The Member Secretary,  
Chennai Metropolitan  
Development Authority,  
No.1, Gandhi Irwin Road,  
CHENNAI -600 008.

Letter No. A2/39969/2003

Dated: 09-07-2004

Sub: CMDA - Planning Permission - Construction  
of Stilt+SF (part) with 4 dwelling units  
Residential Building at Plot No.10, Sri  
Hanuman Nagar, Chennai in S.No.70/3 of  
Gowrivakkam Village - Development charge  
and other charges to be remitted - Reg.

PLAN SHOWING THE PROPOSED RESIDENTIAL BUILDING AT PLOT NO. 10, SRI HANUMAN NAGAR, IN OLD S.NO: 70 PART, PRESENT S.NO: 70/3, AS PER PATTAH: 453, AT OLD NO: 141, NEW NO: 30, GOWRIVAKKAM VILLAGE, TAM BARAM TALUK, KANCHEEPURAM DISTRICT.

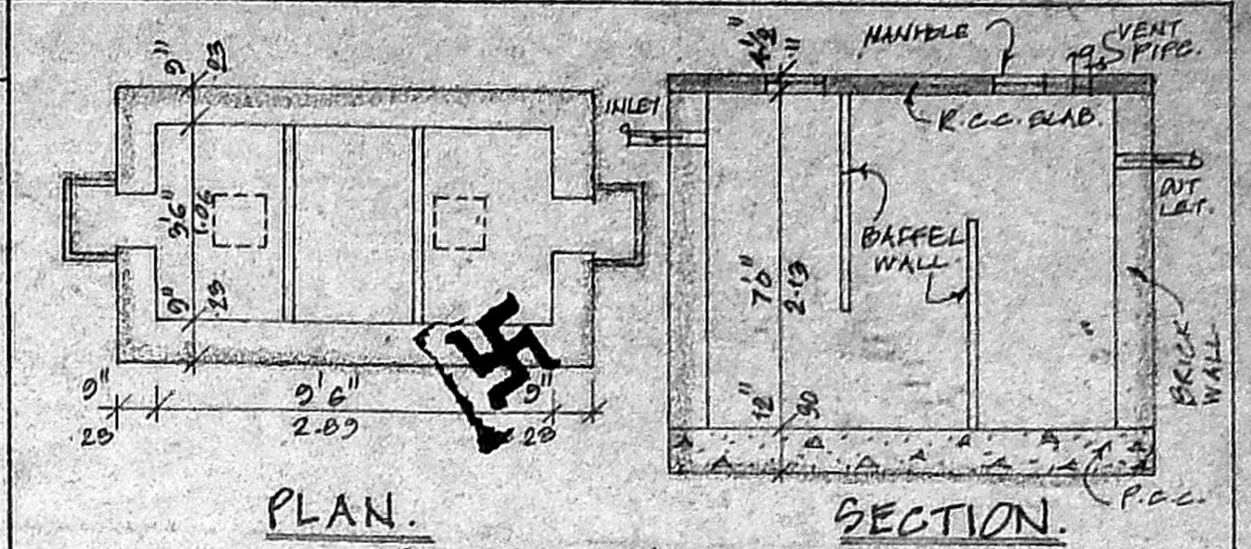
b) 5 copies of revised plan to be furnished by correctly mentioning the sub-title of the plan and section details of compound wall.
